(Development Charges Letter)

File No. : **CMDA/PP/NHRB/C/0235/2020**

Sub: CMDA-Area plans Unit - 'B' Channel (Central) – The Planning Permission application received for the pro construction of Stilt + 4 floors Office building at Old Door No.3, New Door No.7, Thirumurthy Nagar 6th Str Nungambakkam, Chennai comprised in R.S.No. 129/1 (as per document), R.S.No.129/3, Block No.21 (as Patta) of Nungambakkam village within the limit of Greater Chennai Corporation Remittance of DC & Oth charges – DC advice Sent - Reg

Drawing file: PDF / APPROVED PLAN.pdf

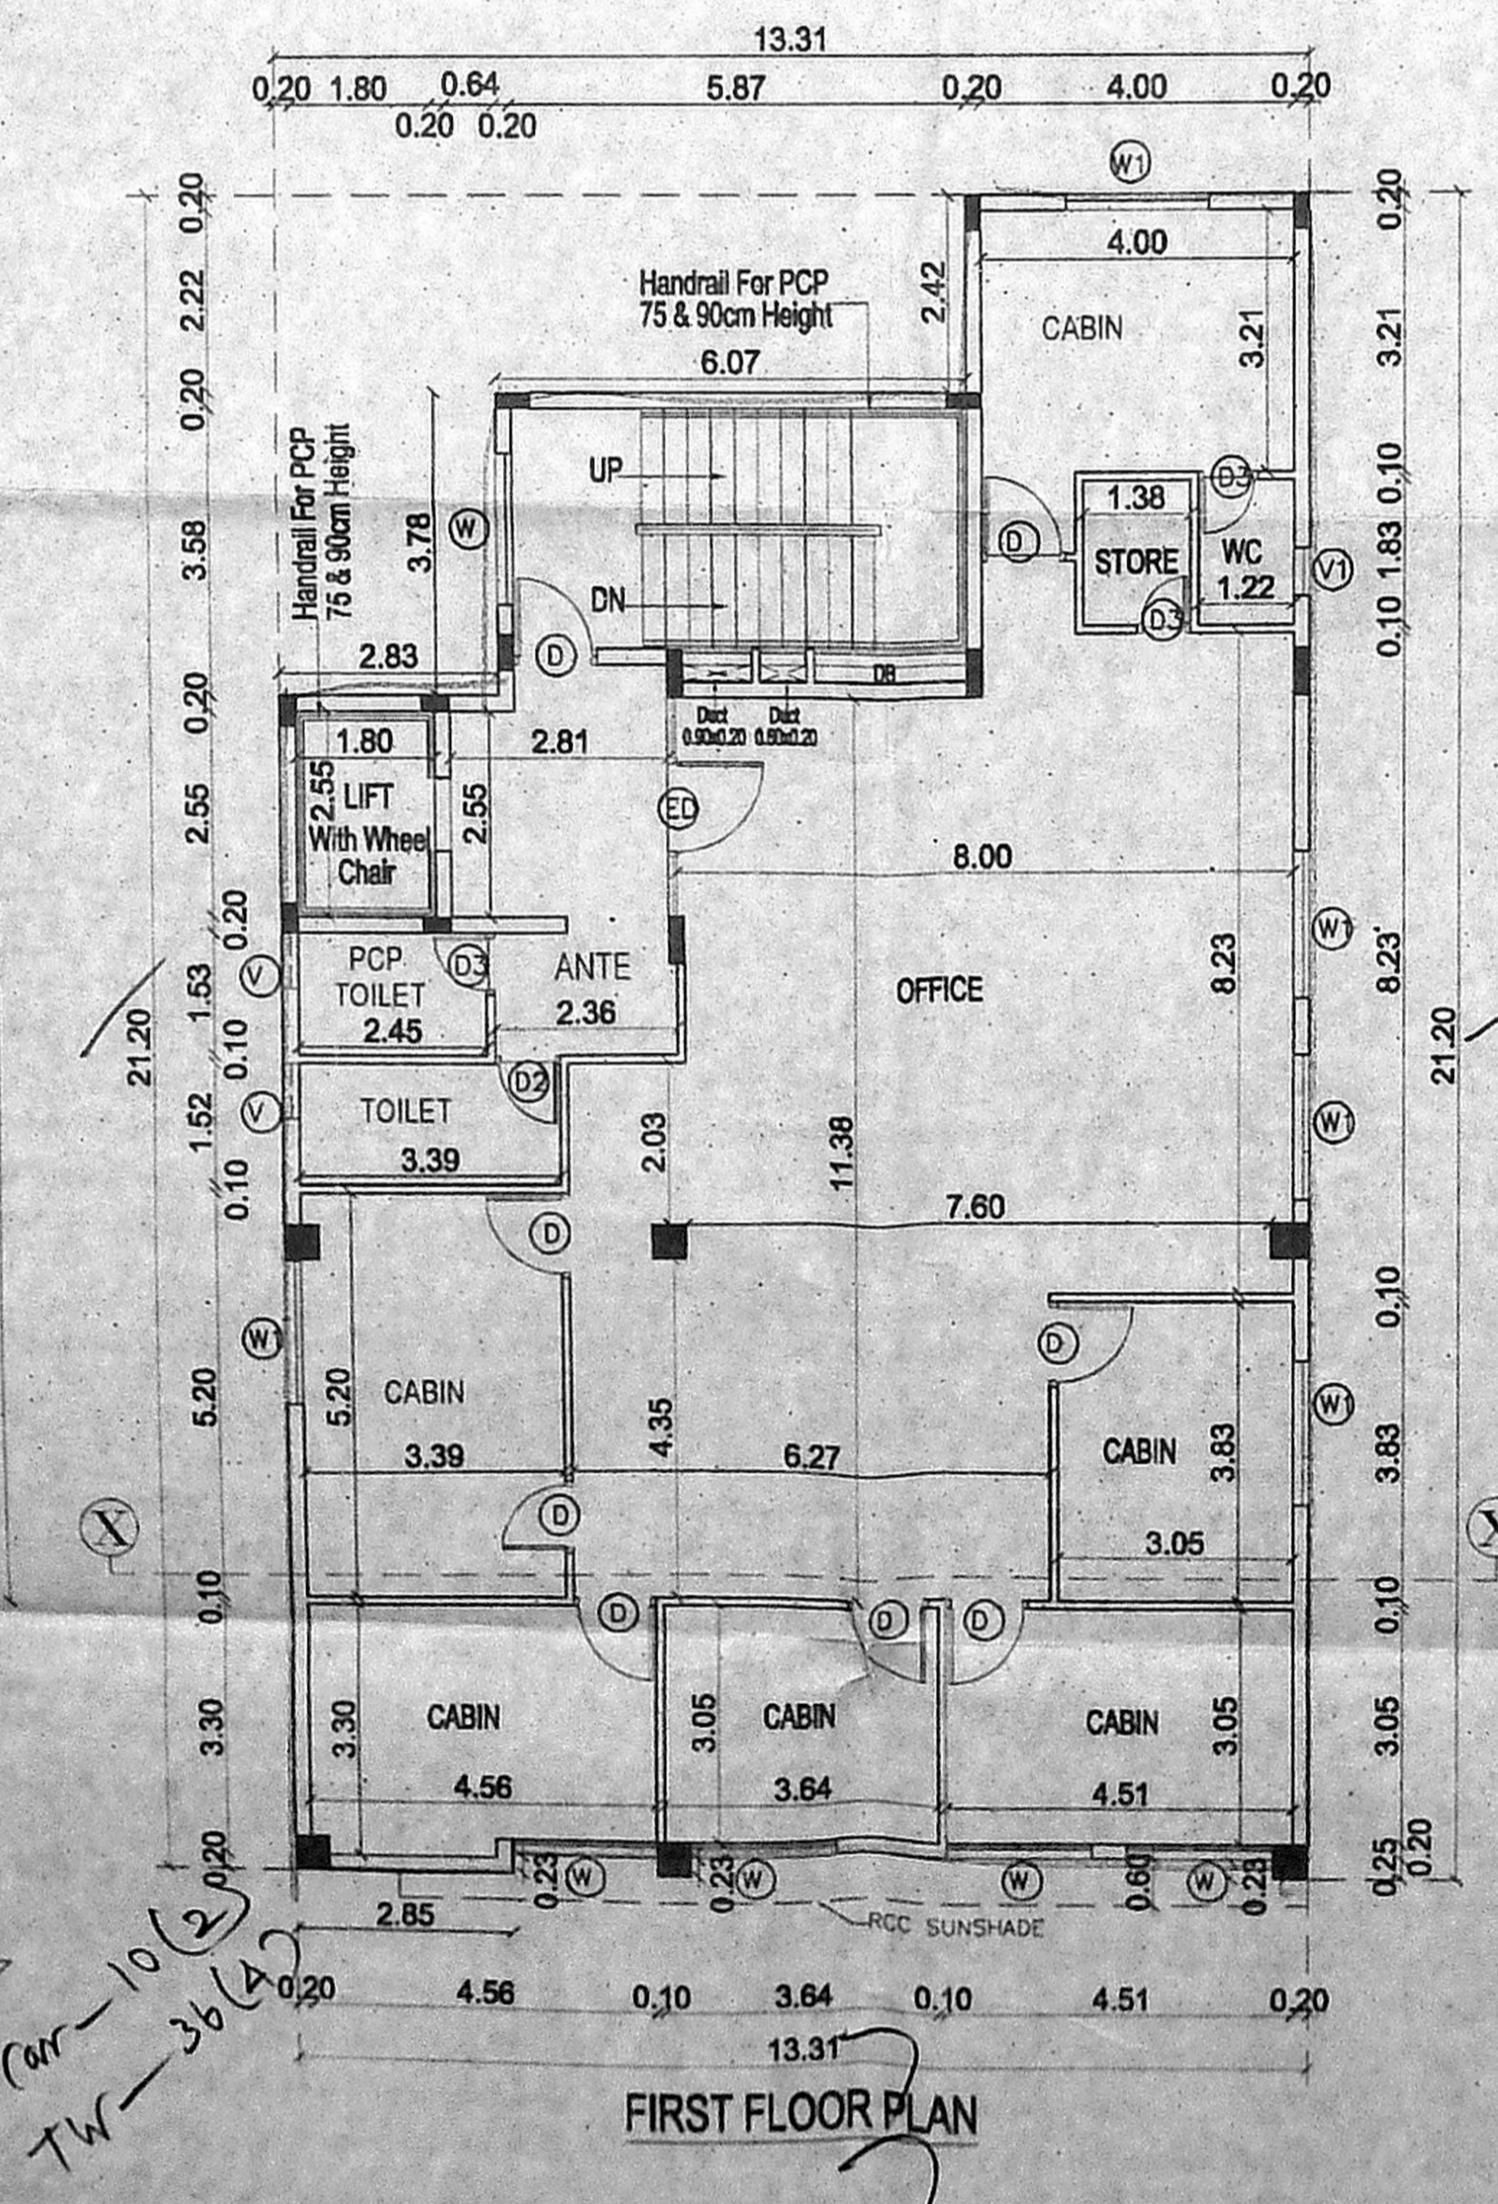
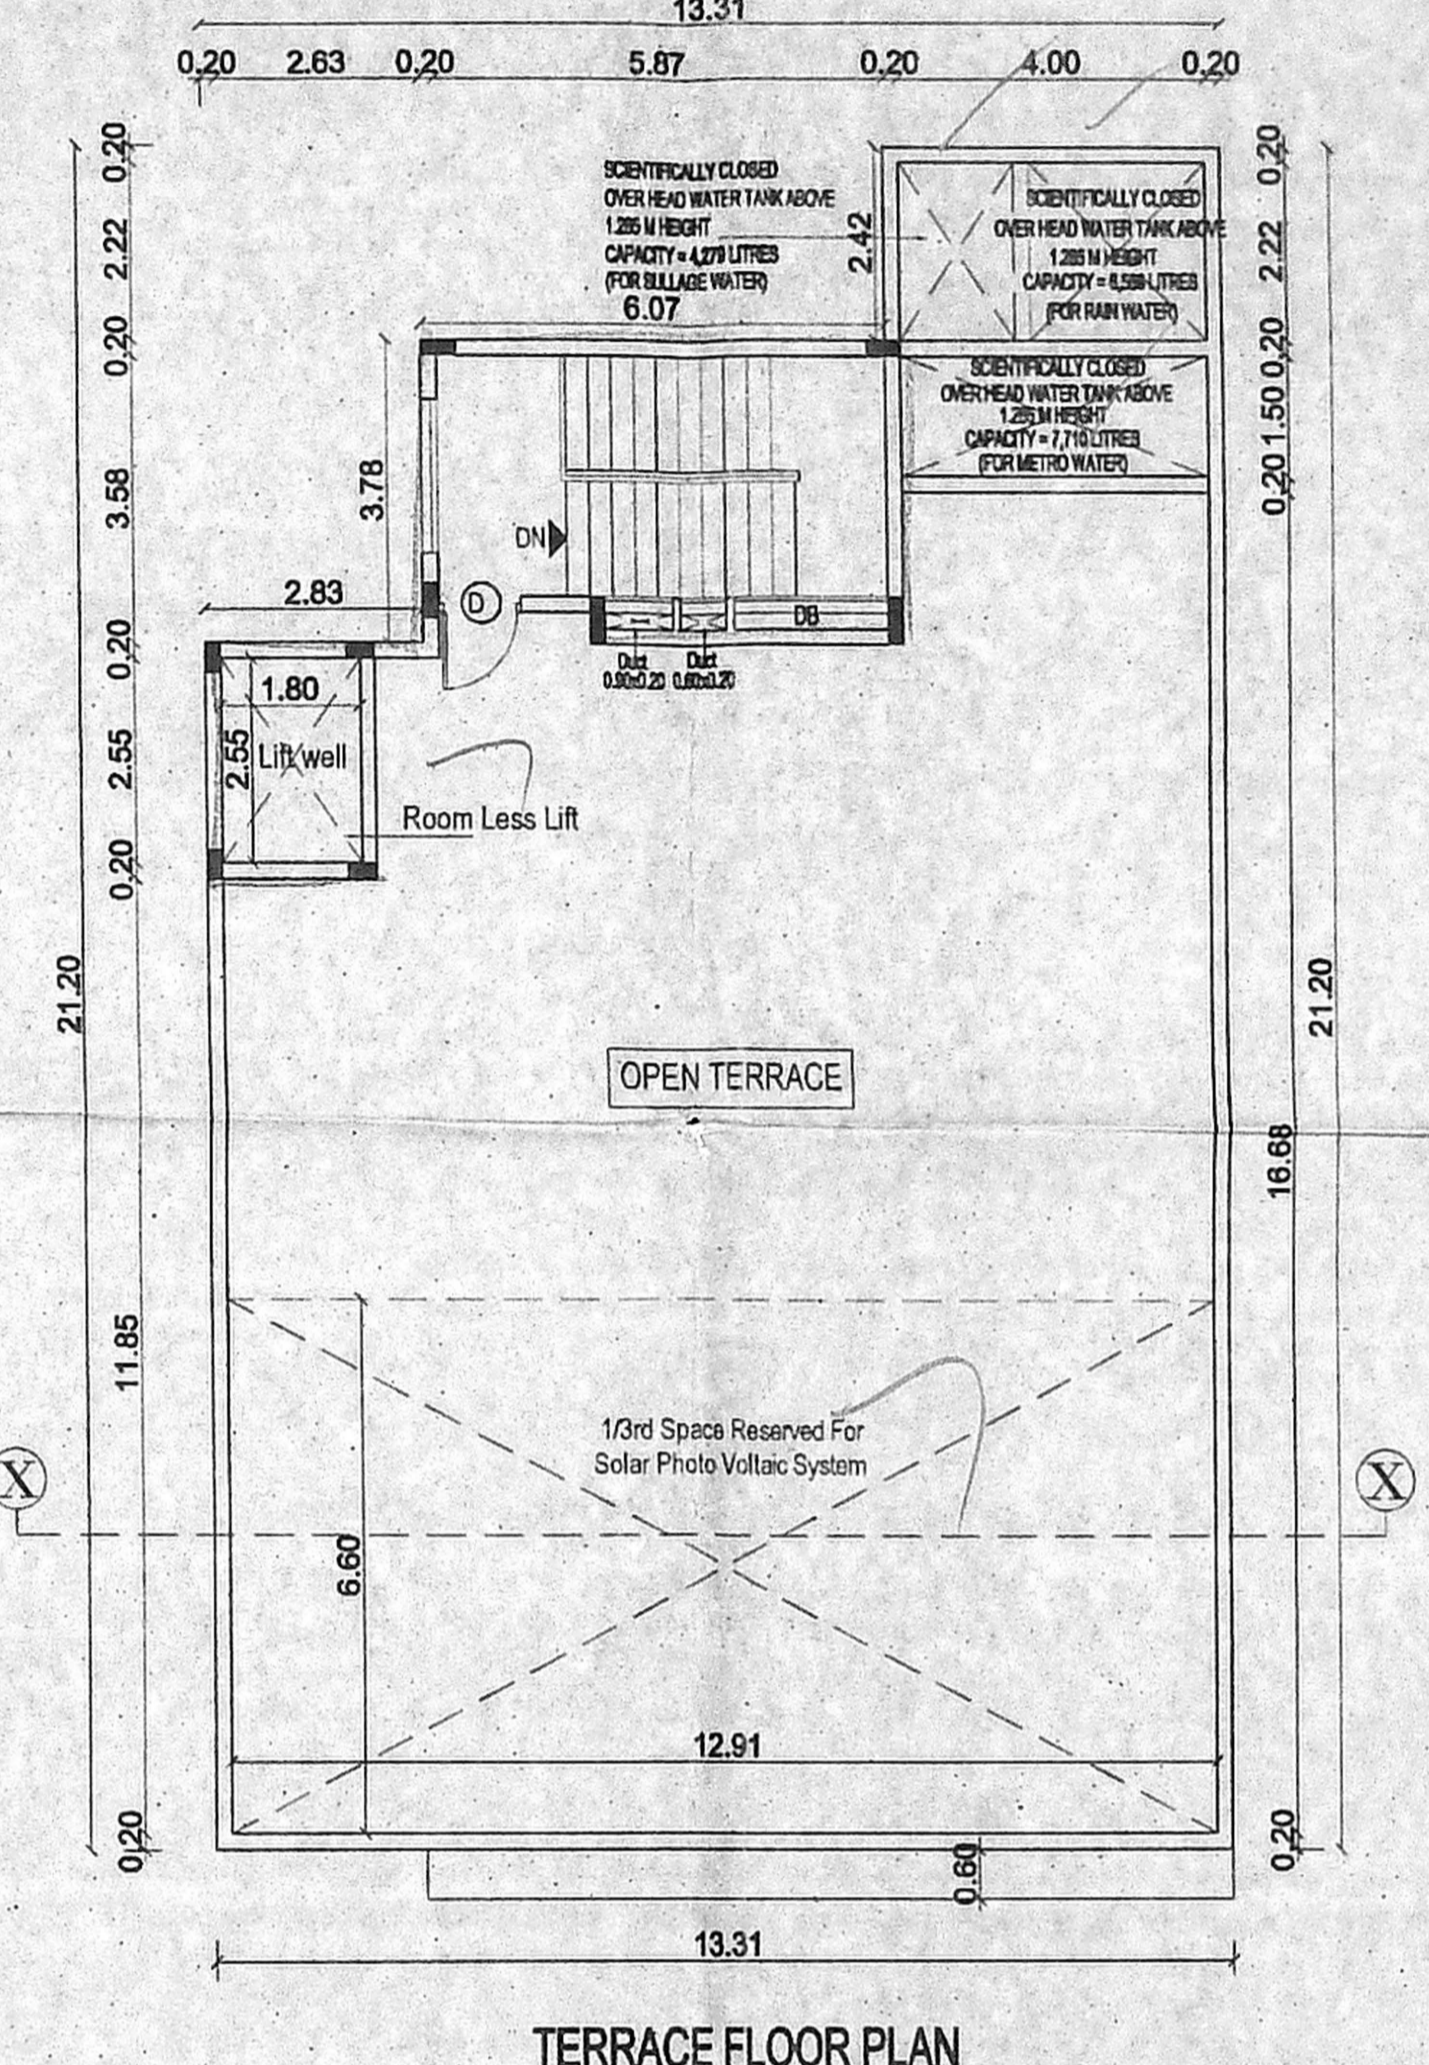
- PCP T.W. parking less by 4 nos (Required-4 nos, Provided =Nil)
- PCP toilet to be provided in 4th floor plan.
- Survey plan duly attested by Revenue officials not below the rank of deputy Tahsildar to be furnished.
- Set back dimensions are to be shown correctly.
- Area statement, Title of plan, Road width, Terrace floor plan, Section and Elevation to be shown correctly.
- Original legal opinion from Govt. Pleader for the ownership rights on Site u/r to be furnished.
- CMDA Registration copy for Developer is to be furnished.
- Form C in Rs.20/- stamp paper as per the format prescribed in TNCD& BR to be furnished.
- RCC sunshade at front set back to be shown in hidden line.
